EL PASO COUNTY PLANNING AND COMMUNITY DEVELOPMENT DEPARTMENT

STORMWATER MANAGEMENT PLAN CHECKLIST

GRADING & EROSION CONTROL PLAN

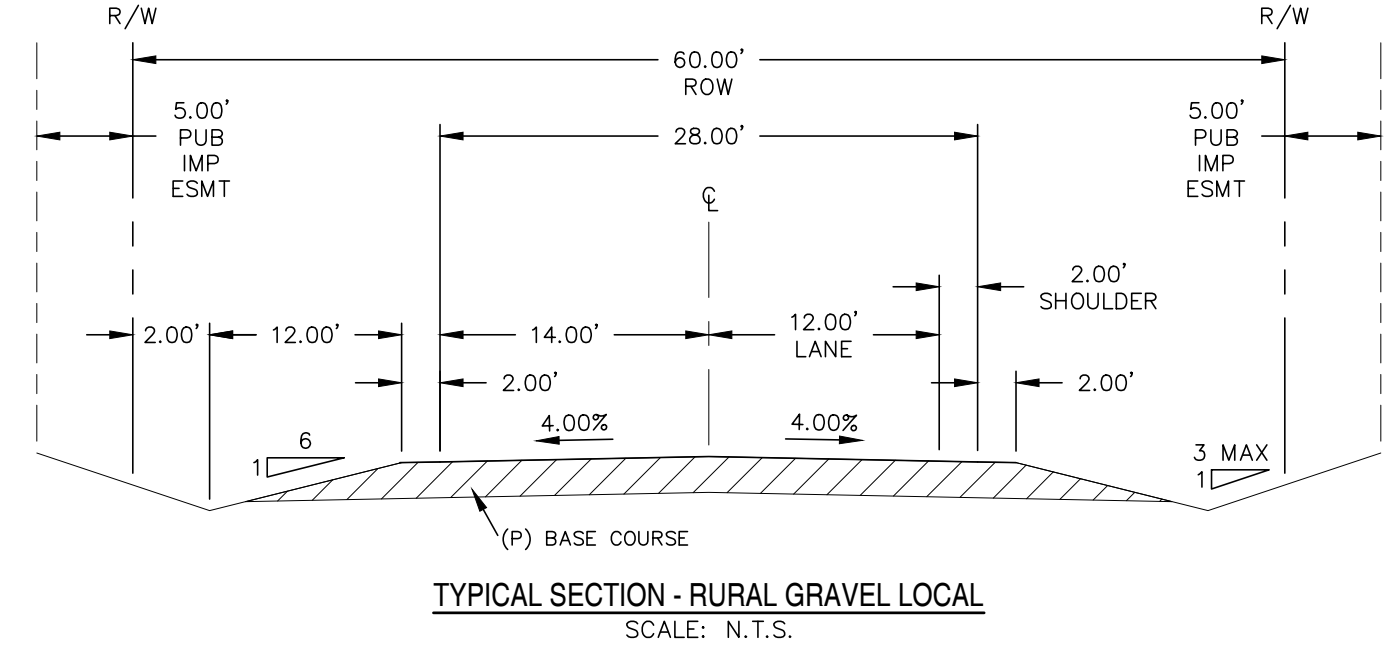
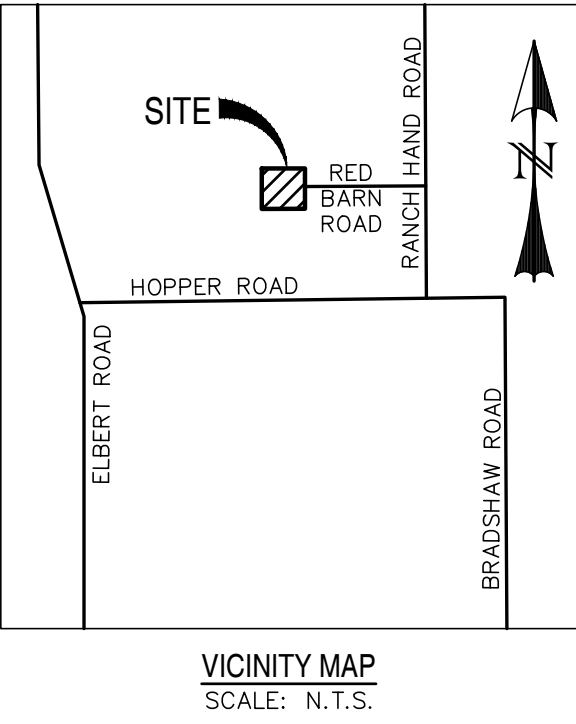
Applicant	PCD
1. STORMWATER MANAGEMENT PLAN (SWMP)			
1	Applicant (owner/designated operator), SWMP Preparer, Qualified Stormwater Manager, and Contractor Information. (On cover/title sheet)	X	X
2	Table of Contents	X	✓
3	Site description and location to include: vicinity map with nearest street/crossroads description.	X	✓
4	Narrative description of construction activities proposed (e.g., may include clearing and grubbing, temporary stabilization, road grading, utility / storm installation, final grading, final stabilization, and removal of temporary control measures)	X	✓
5	Phasing plan – may require separate drawings indicating initial, interim, and final site phases for larger projects. Provide "living maps" that can be revised in the field as conditions dictate.	N/A	X
6	Proposed sequence for major activities: Provide a construction schedule of anticipated starting and completion dates for each stage of land-disturbing activity depicting conservation measures anticipated, including the expected date on which the final stabilization will be completed.	X	X

Revised: July 2019		Applicant	PCD
17	SWMP Map to include:		
17a	construction site boundaries	X	X
17b	flow arrows to depict stormwater flow directions		X
17c	all areas of disturbance	X	✓
17d	areas of cut and fill		X
17e	areas used for storage of building materials, soils (stockpiles) or wastes	X	✓
17f	location of any dedicated asphalt / concrete batch plants n/a	N/A	✓
17g	location of all structural control measures	N/A	X
17h	location of all non-structural control measures	X	✓
17i	springs, streams, wetlands and other surface waters, including areas that require maintenance of pre-existing vegetation within 50 feet of a receiving water n/a	N/A	✓
18	Narrative description of all structural control measures to be used. Modifications to EPC standard control measures must meet or exceed County-approved details.	N/A	X
19	Description of all non-structural control measures to be used including seeding, mulching, protection of existing vegetation, site watering, sod placement, etc.	X	✓

20	Technical drawing details for all control measure installation and maintenance; custom or other jurisdiction's details used must meet or exceed EPC standards	X	X
21	Procedure describing how the SWMP is to be revised	X	X
22	Description of Final Stabilization and Long-term Stormwater Quality (describe nonstructural and structural measures to control SW pollutants after construction operations have been completed, including detention, water quality control measure etc.)	X	✓
23	Specification that final vegetative cover density is to be 70% of pre-disturbed levels	X	✓
24	Outline of permit holder inspection procedures to install, maintain, and effectively operate control measures to manage erosion and sediment	X	✓
25	Record keeping procedures identified to include signature on inspection logs and location of SWMP records on-site	X	✓
26	If this project relies on control measures owned or operated by another entity, a documented agreement must be included in the SWMP that identifies location, installation and design specifications, and maintenance requirements and responsibility of the control measure(s).	N/A	X
